Addendum No. 2

RE: Contract # C204507

Cumberland County (U-5798A)

SR-1102 FROM NORTH OF SR-1112 TO US-401 AND REPLACE BRIDGE
250075 OVER LITTLE ROCKFISH CREEK.

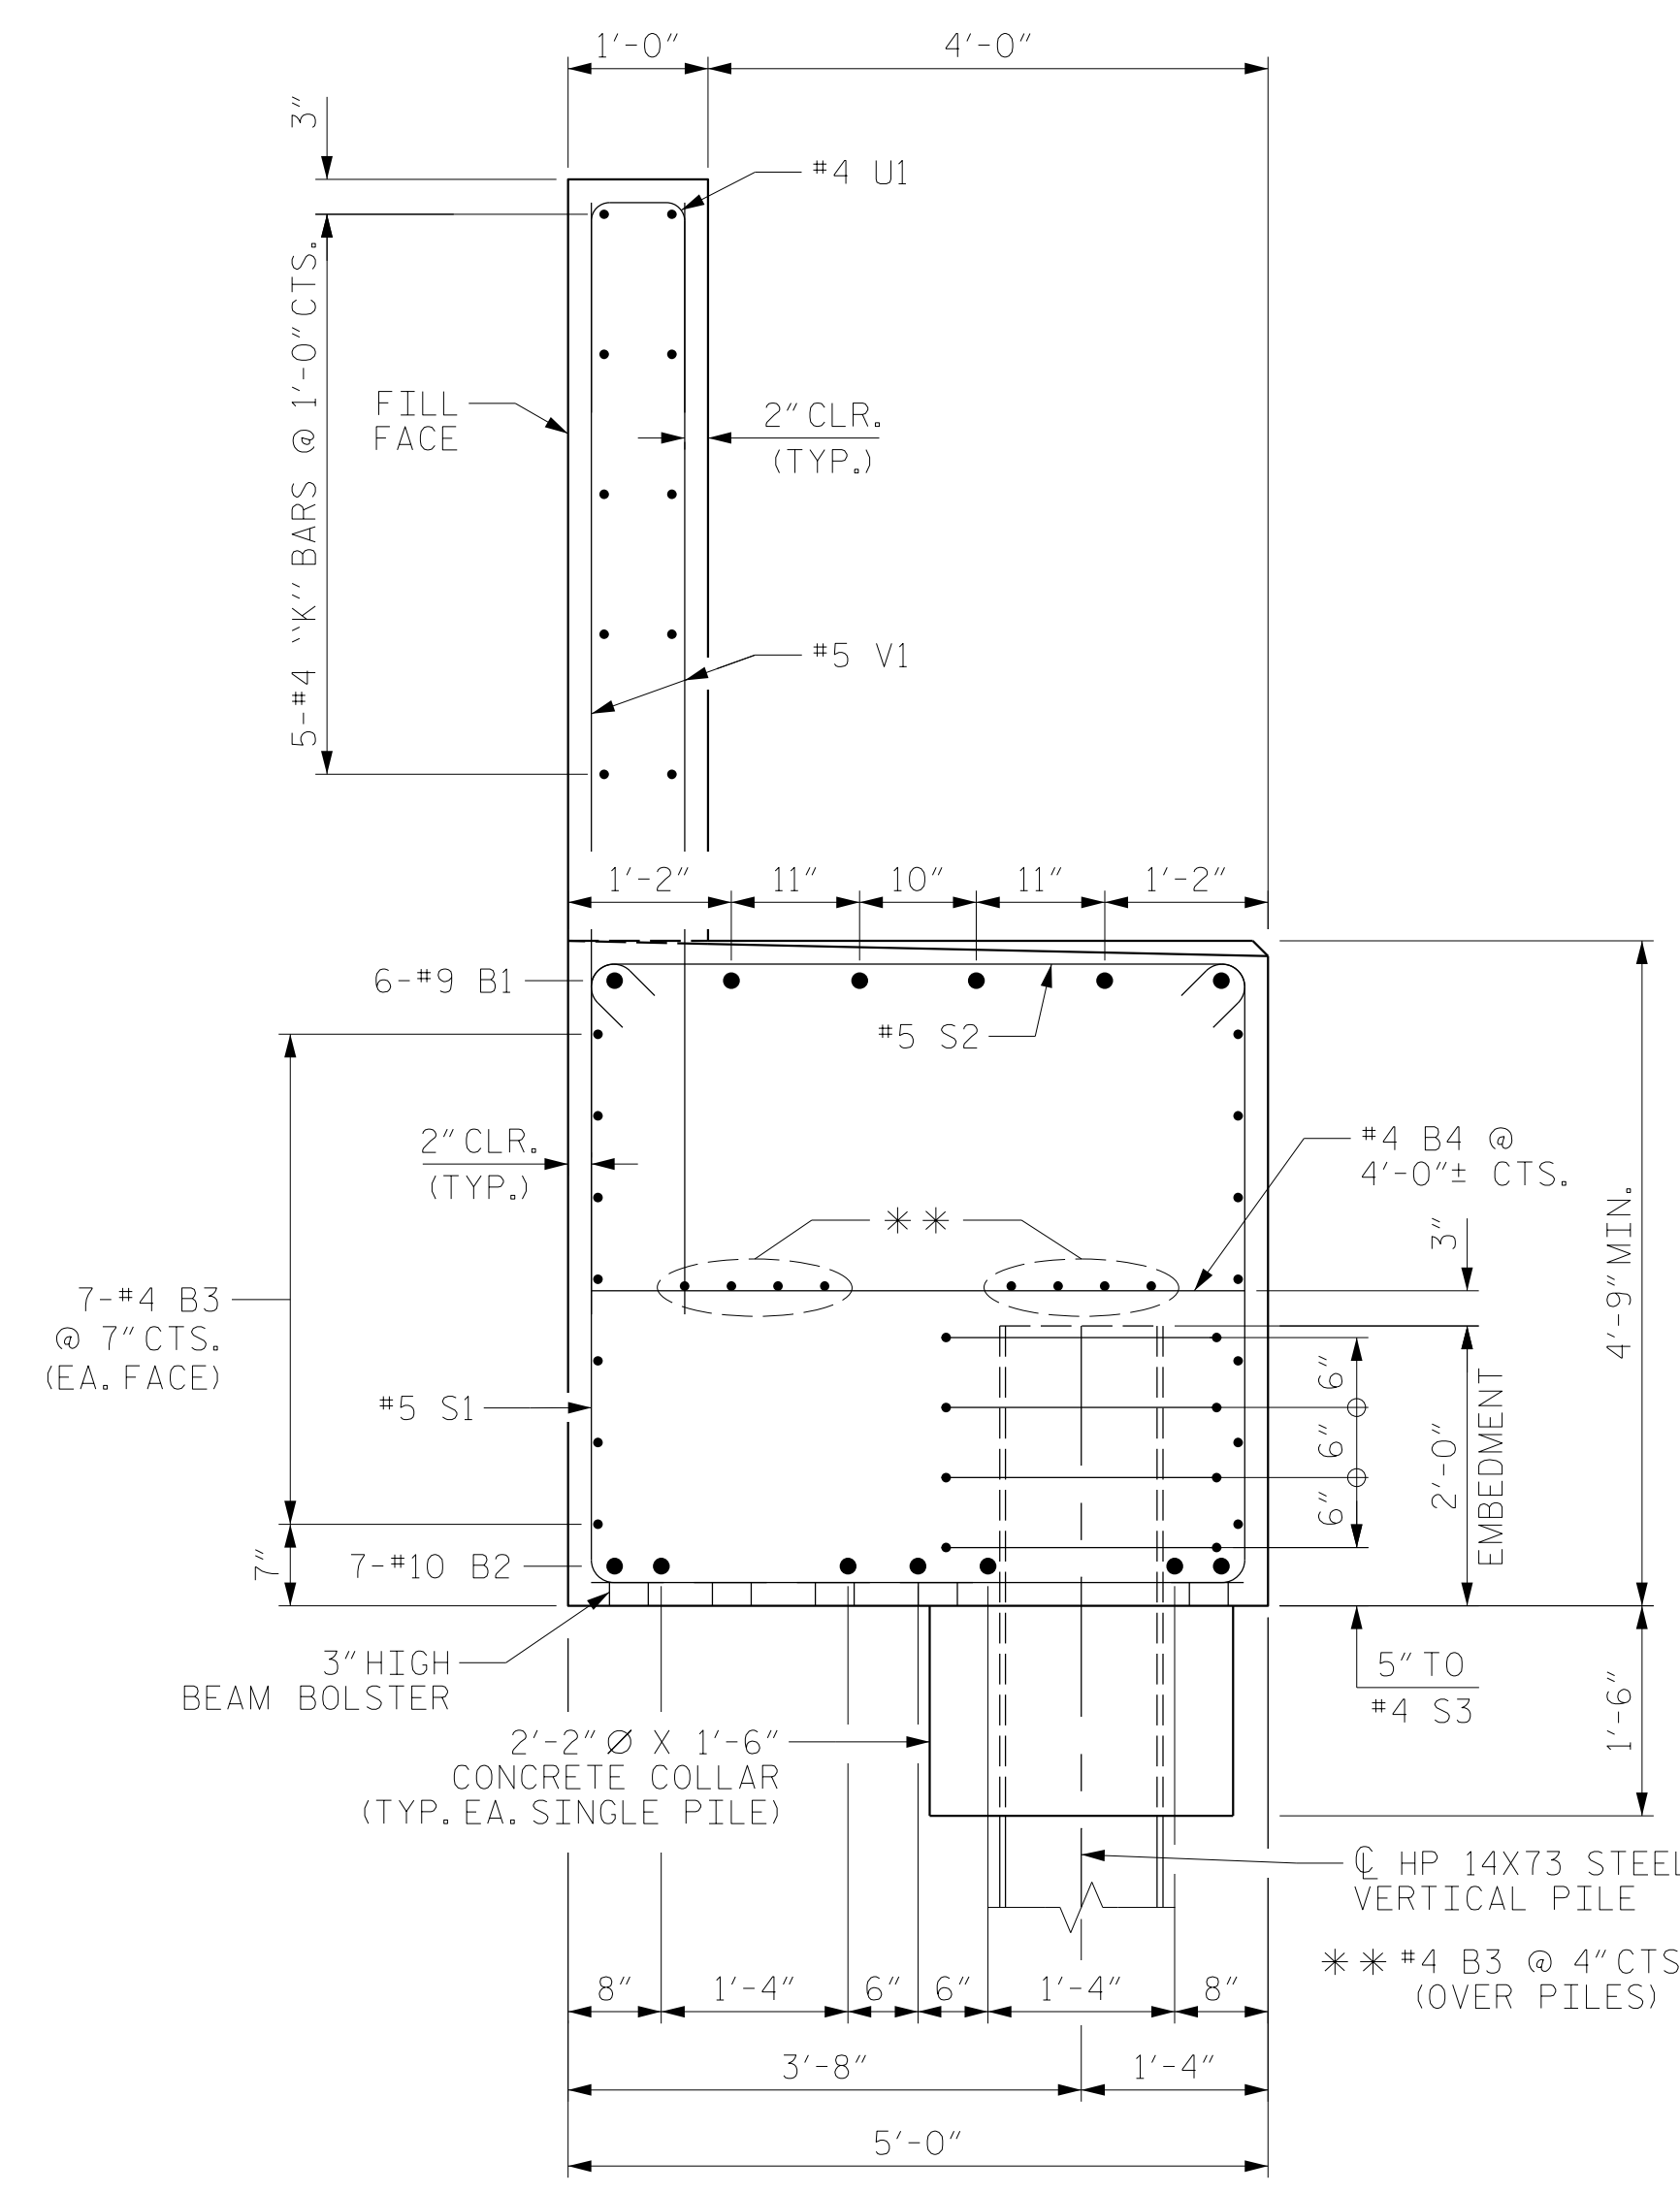
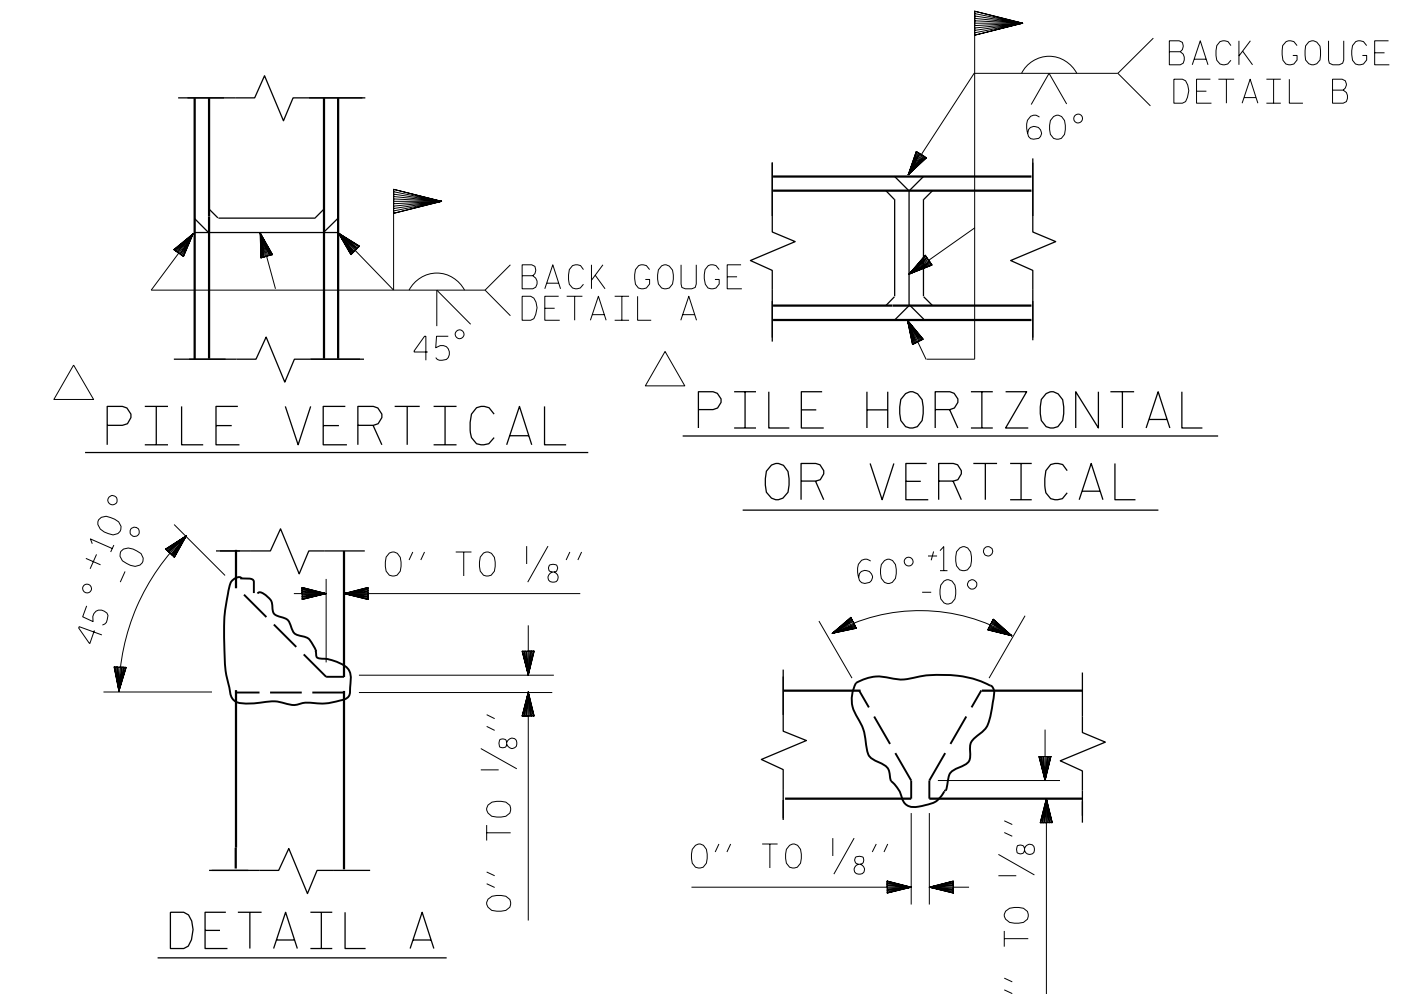
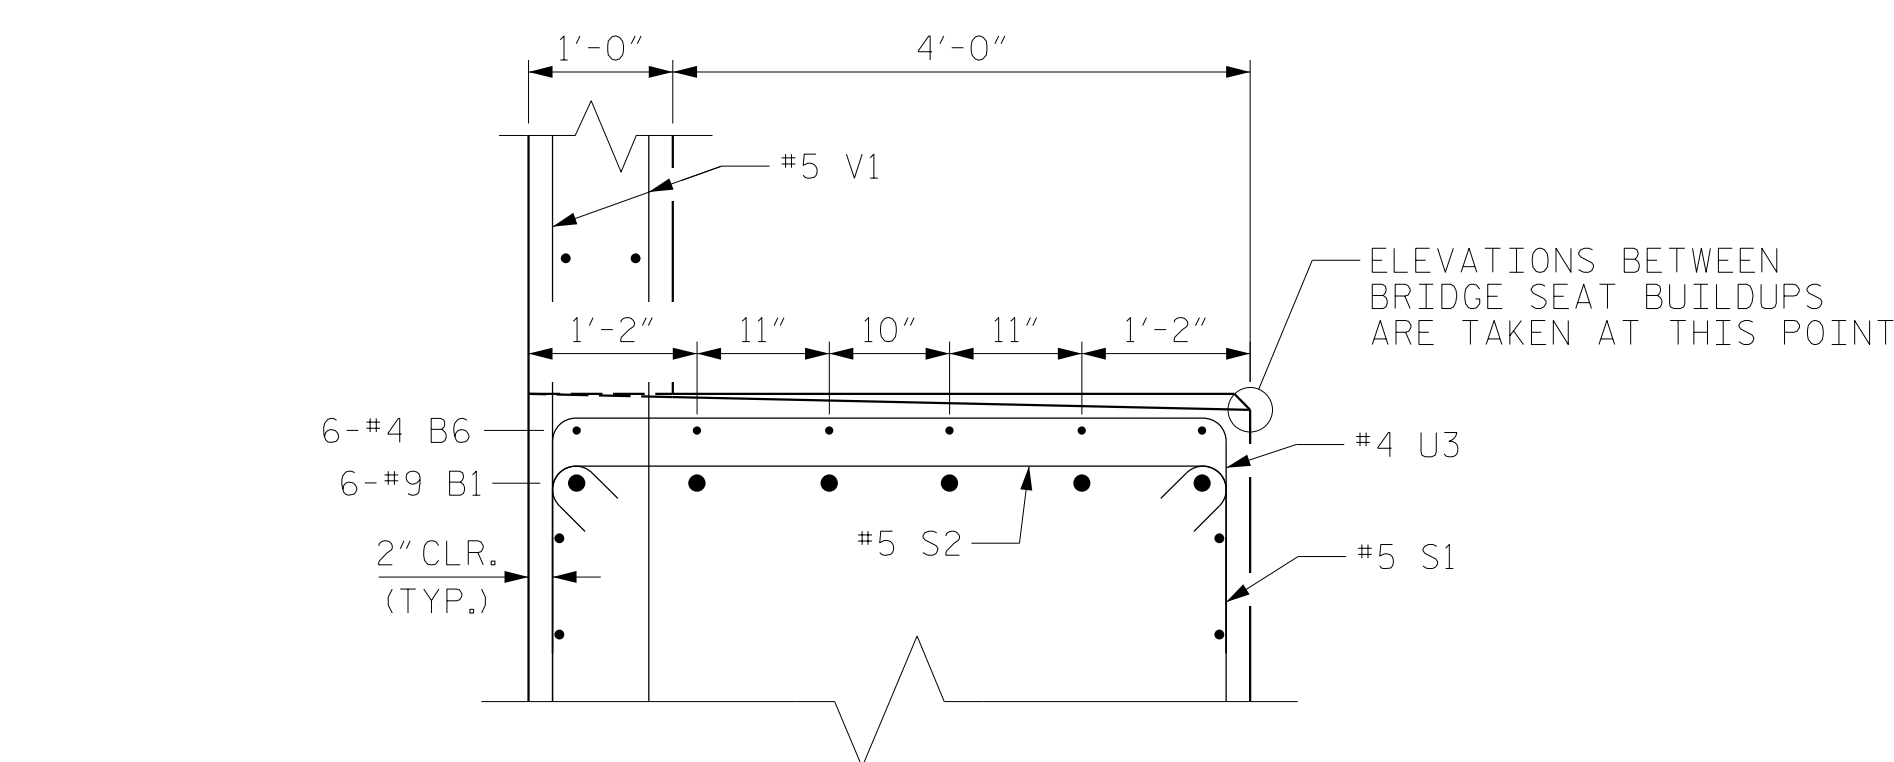
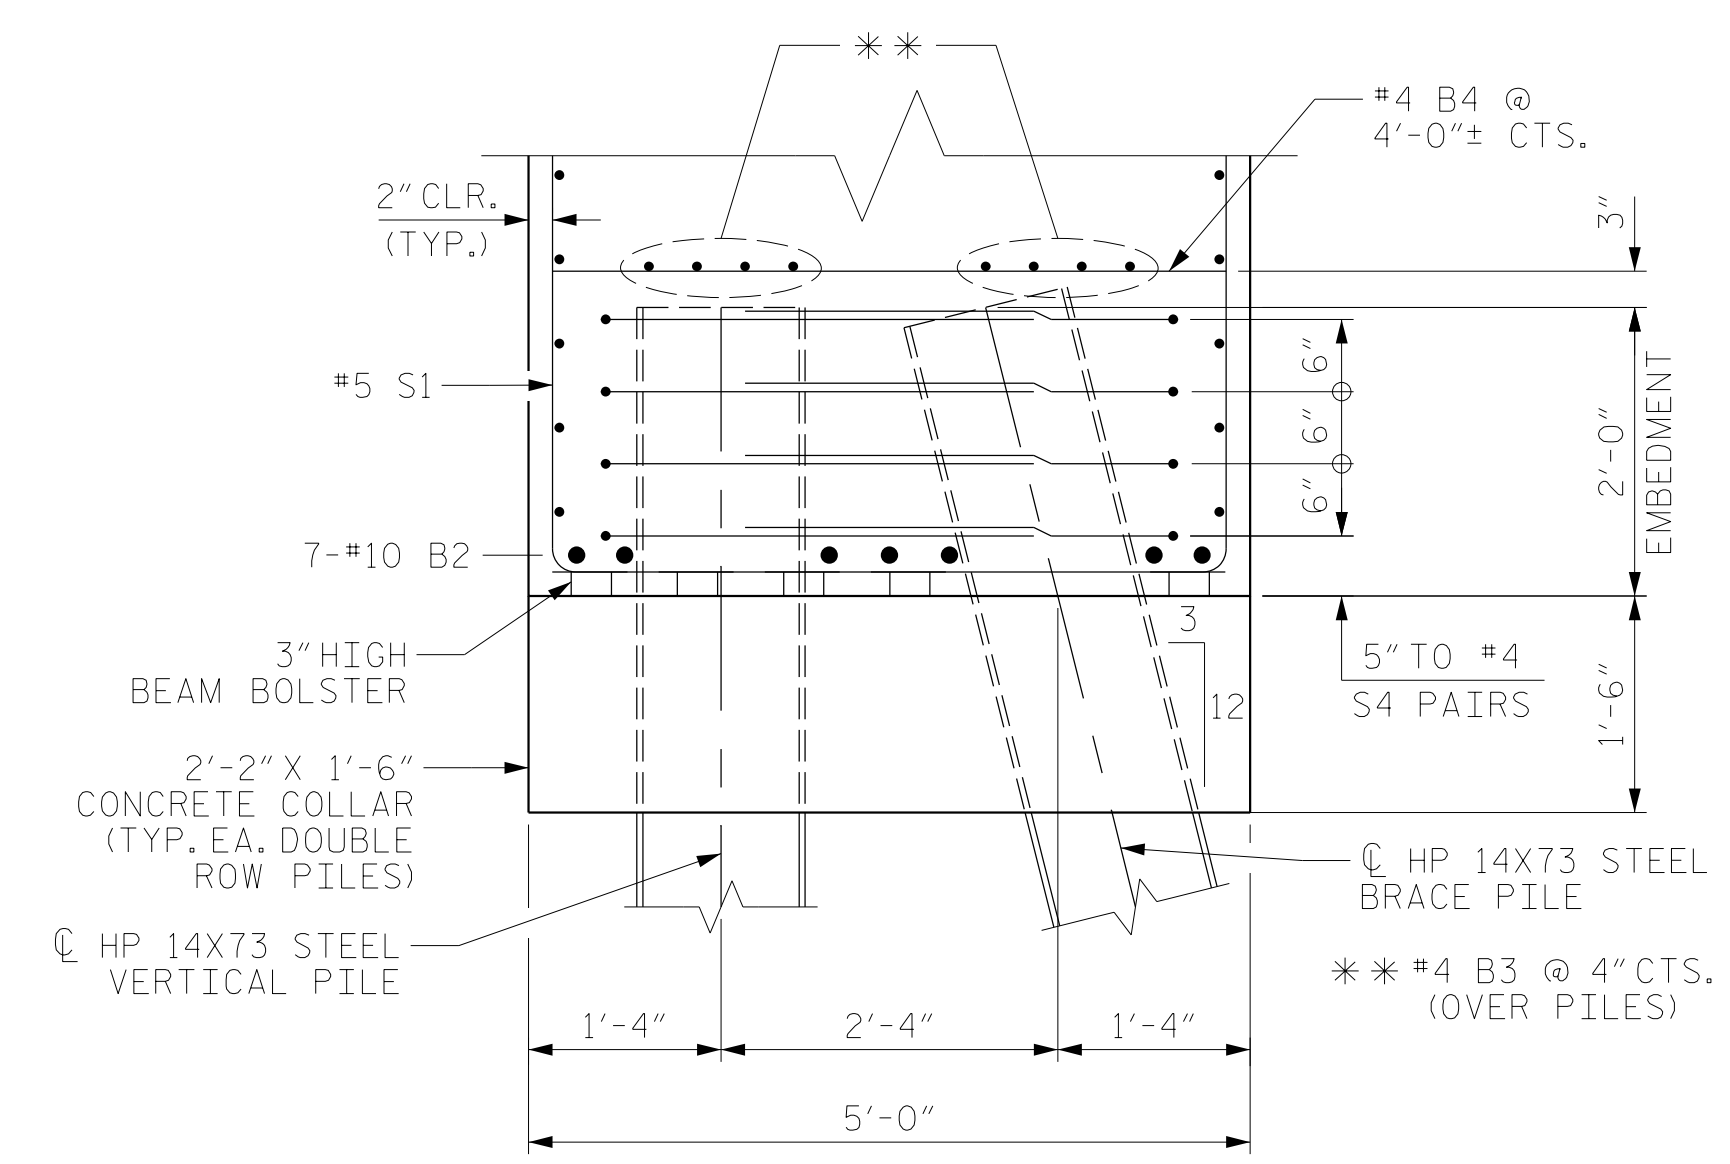
Sheet No.	Revision
S1-3	Updated to reflect quantity changes.
S1-33	Updated to reflect quantity changes.
S1-39	Updated to reflect quantity changes.
S2-3	Updated to reflect quantity changes.
S2-33	Updated to reflect quantity changes.
S2-39	Updated to reflect quantity changes.

<u>Item</u>	<u>Description</u>	<u>Old Quantity</u>	<u>New Quantity</u>
0240-8328200000-E-450	PILE DRIVING EQUIPMENT SETUP FOR HP 14 X 73 STEEL PILES	40 EA	44 EA
0242-8384000000-E-450	HP 14X73 STEEL PILES	2,580 LF	2,840 LF
